CITY OF ALBUQUERQUE

August 23, 2022

Re: AVID HOTEL
1441 Woodard Road SE
Traffic Circulation Layout
Architect's Stamp NONE (M15-D023B)

SP-1

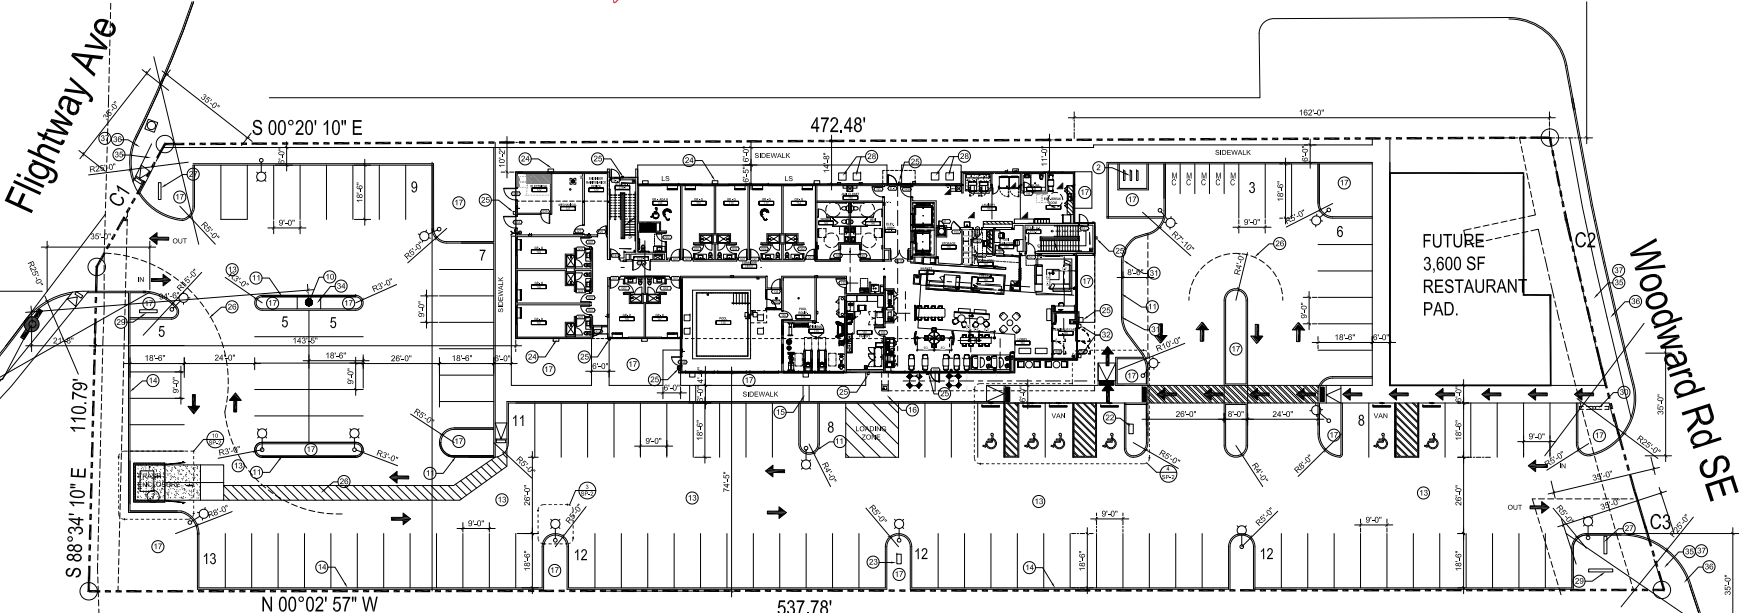
1. Listed are the number of parking spaces required by the IDO as well as the proposed number of parking spaces including bicycle and motorcycle parking. Coordinate/discuss with Zoning. **Shown are the requirements for Hotel but not for Future Restaurant. So, please break down and separate required calculations for Hotel versus Restaurant.**

- Some keyed notes shown on items are incorrect. Please address this concern.
 - **Keyed notes 29 & 30:** Verify that location of proposed signs will not encroach onto COA right of way. This includes airspace.

5. **Woodard/Flightway proposed entrances:**
 - Provide entrance design detail and/or reference COA Std Dwg 2426.
 - Ramp symbols will need to be provide to demonstrate propose ramps with truncated domes.

- **Sidewalk (proposed/existing):** Provide width and details (or reference COA std dwg 2430).
 - **Sidewalk end treatment:** Provide (Note) a 5:1 taper to tie into existing ground surface to avoid tripping hazard at end of sidewalk (if applicable).

6. Identify all existing access easements and rights of way width dimensions (If applicable).
7. Identify the right of way width, medians, curb cuts, and street widths on Woodard and Flightway.
8. Please list the width and length for all proposed parking spaces. Some dimensions are not shown.
9. The minimum parking stall dimensions are:

25. A hard driving surface will be required as part of this proposed project for parking area and drive aisles. **Please provide thickness of propose asphalt surface for site.**

26. Please provide a sight distance exhibit and proposed entrances and dimension them appropriately.
27. Show the clear sight triangle and add the following note to the plan: "Landscaping and signage will not interfere with clear sight requirements. Therefore, signs, walls, trees, and shrubbery between 3 and 8 feet tall (as measured from the gutter pan) will not be acceptable in the clear sight triangle. **Sight triangle Not properly shown on site plan.**

28. Please specify the City Standard Drawing Number when applicable.
29. Add a note stating "All broken or cracked sidewalk must be replaced with sidewalk and curb & gutter." A build note must be provided referring to the appropriate City Standard drawing (2430 & 2415A).
